OUT21/12755

**New Cobar Complex Project (SSD-10419)
Response to Submissions (RTS)**

Liz Rogers
Manager, Assessments, Knowledge Division
Department of Planning, Industry and Environment: Water
12 October 2021

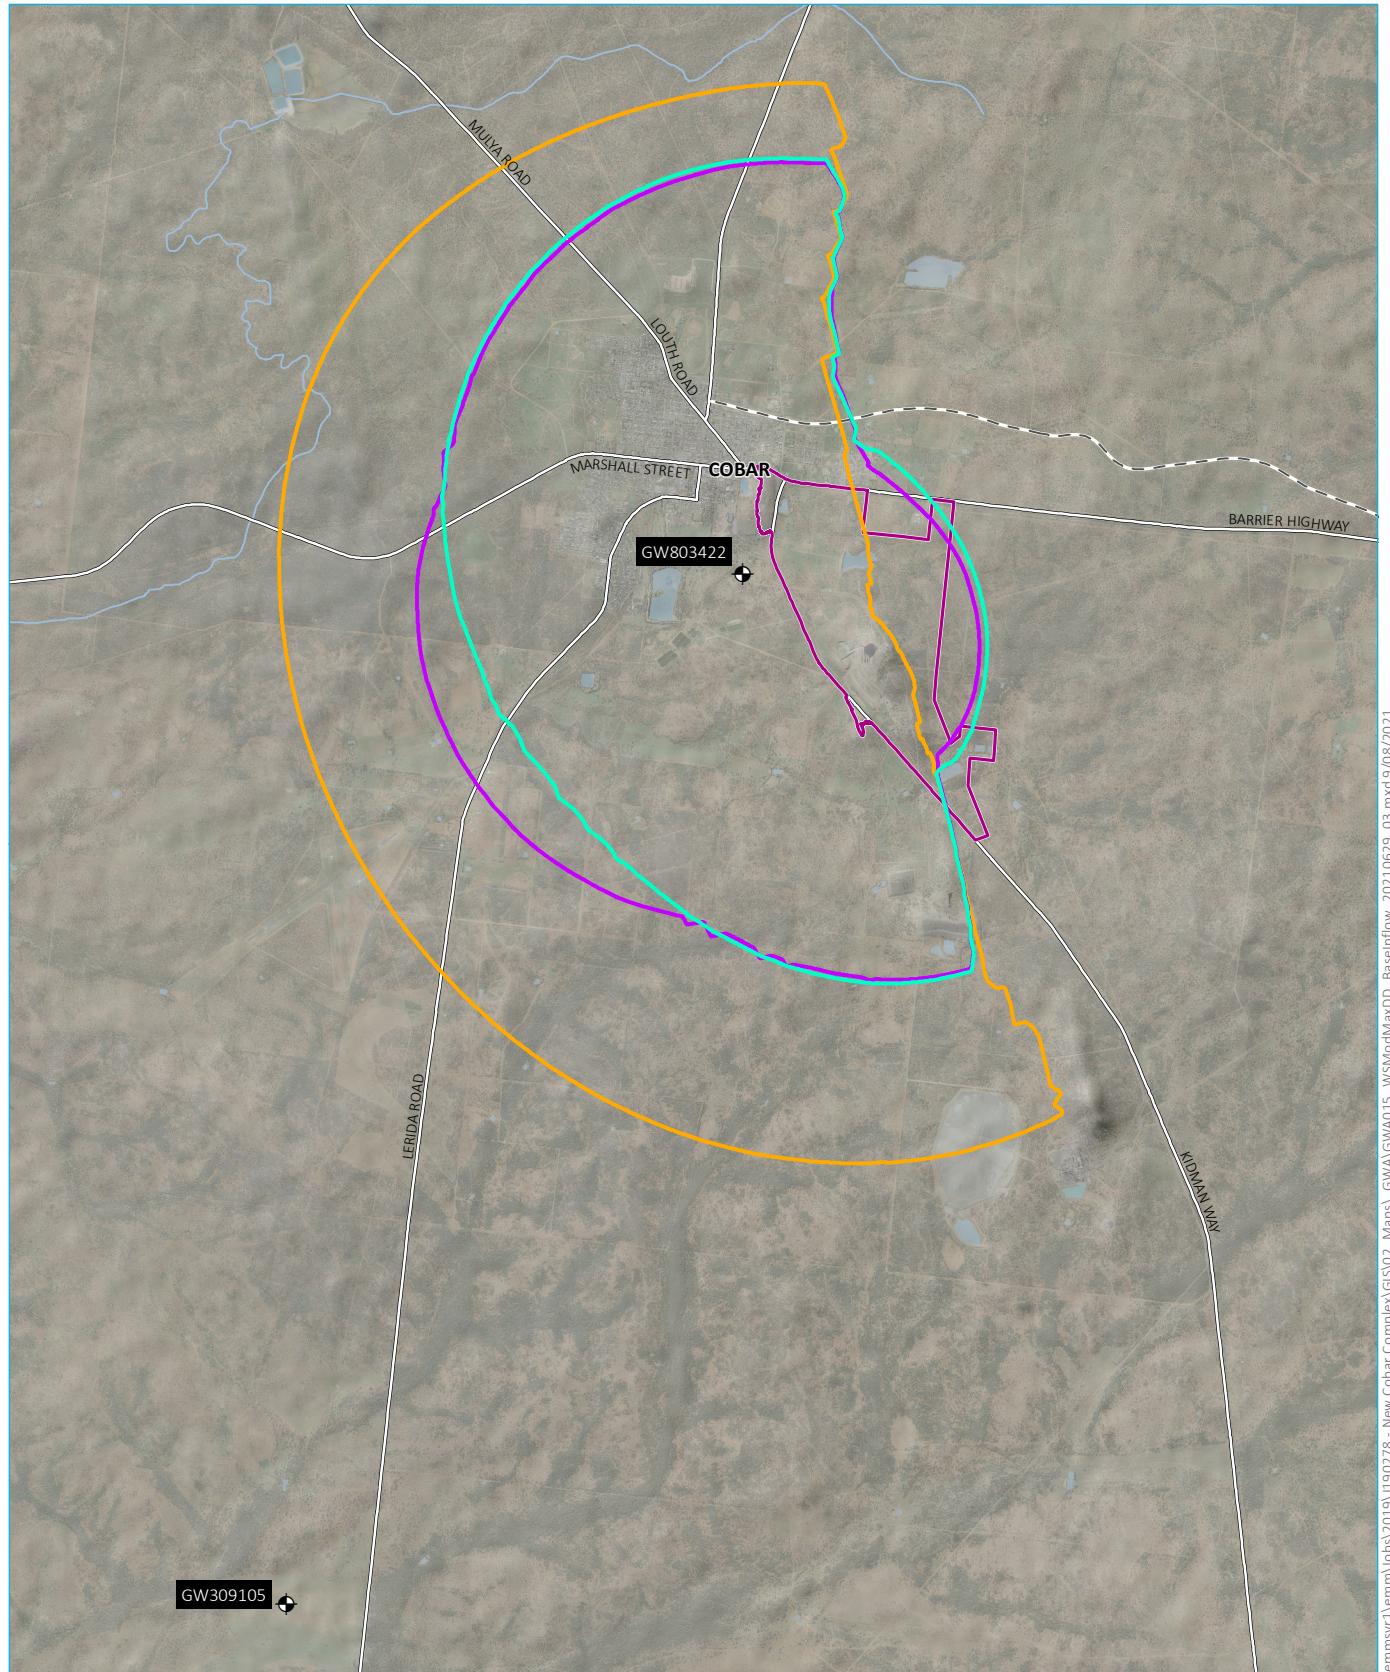
DPIE Water and NRAR have reviewed the RTS and still have remaining concerns regarding the correct identification and assessment of the neighbouring basic landholder right (BLR) bore.

- correctly identify and assess the neighbouring BLR bore, 85WA752553, ESID103824 and rerun the groundwater model to determine the impact on the bore
